Case Officer: Hannah Kersley
Reference: AW/43/22/T
Location: 210 Manor Way, Aldwick, PO21 4HW
Proposal: Reduce 1no. *macrocarpa* tree by 1.5m to final height 18m and spread 18m
Reasons given: To maintain a dense habit

MACROCARPA

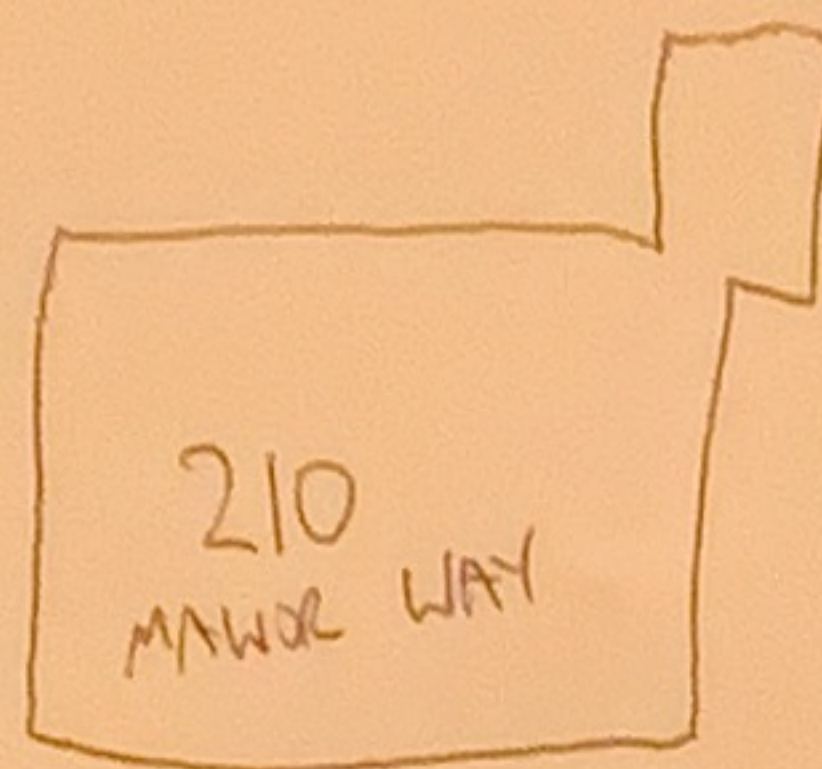
- Outwardly and from roadside this tree appears to be in a fine physiological state and assumed to be so in the absence of any evidence provided to the contrary. It is one of the largest trees on the estate, prominent and with a visually impressive crown. This is unusual for a tree of this type and age. It is a tree of high amenity value.
- There is evidence of past crown reduction pruning, with 1-2metres of extension growth in most places. The applicant/agent states an intention to repeat the last operation, so removing only that growth which has occurred since 2014.
- Repeat operations such as now being asked for by the applicant will be necessary throughout the remaining lifespan of this tree, to achieve a degree of structural integrity appropriate for its location.

- This tree requires careful management that respects its age and vulnerability to environmental changes and disease progression.
- The work proposed is justified on arboricultural grounds. If undertaken to a high standard and at the right time; then it is unlikely to have an adverse effect on the tree's long-term vitality and visual amenity.
- The proposal to reduce overall height and spread with a view to restricting its growth is justified and consistent with previous works approved by the Local Planning Authority.
- Due to the relatively small amount of branch length reduction permitted, it will be very challenging for a climbing arborist (tree surgeon) to complete this work satisfactorily from a rope and harness. To properly respect the 'knuckles' established when first initiated, the appointed contractor may need to utilise a mobile elevating work platform (MEWP).

- Although Cypress may recover from hard pruning (as proposed) they have a poor tolerance of such work and long-term vitality can be severely affected. The optimum time to prune is during the late spring to early summer period (May to June).

- I recommend **CONSENT** is granted subject to the following conditions:

Part a) Where whole branches are to be removed and final cuts made close to the trunk or branch union they are to be made as shown in Figure 2 of BS3998:2010

Part b) Where branches are to be shortened back the final cuts are to be made at the correct angle shown in BS3998:2010 and adjacent to a live bud or lateral.

Part c) The removal of crown material which has developed since the last operation must be done sympathetically and with respect to established 'knuckles' so as not to extend beyond the point of origin.
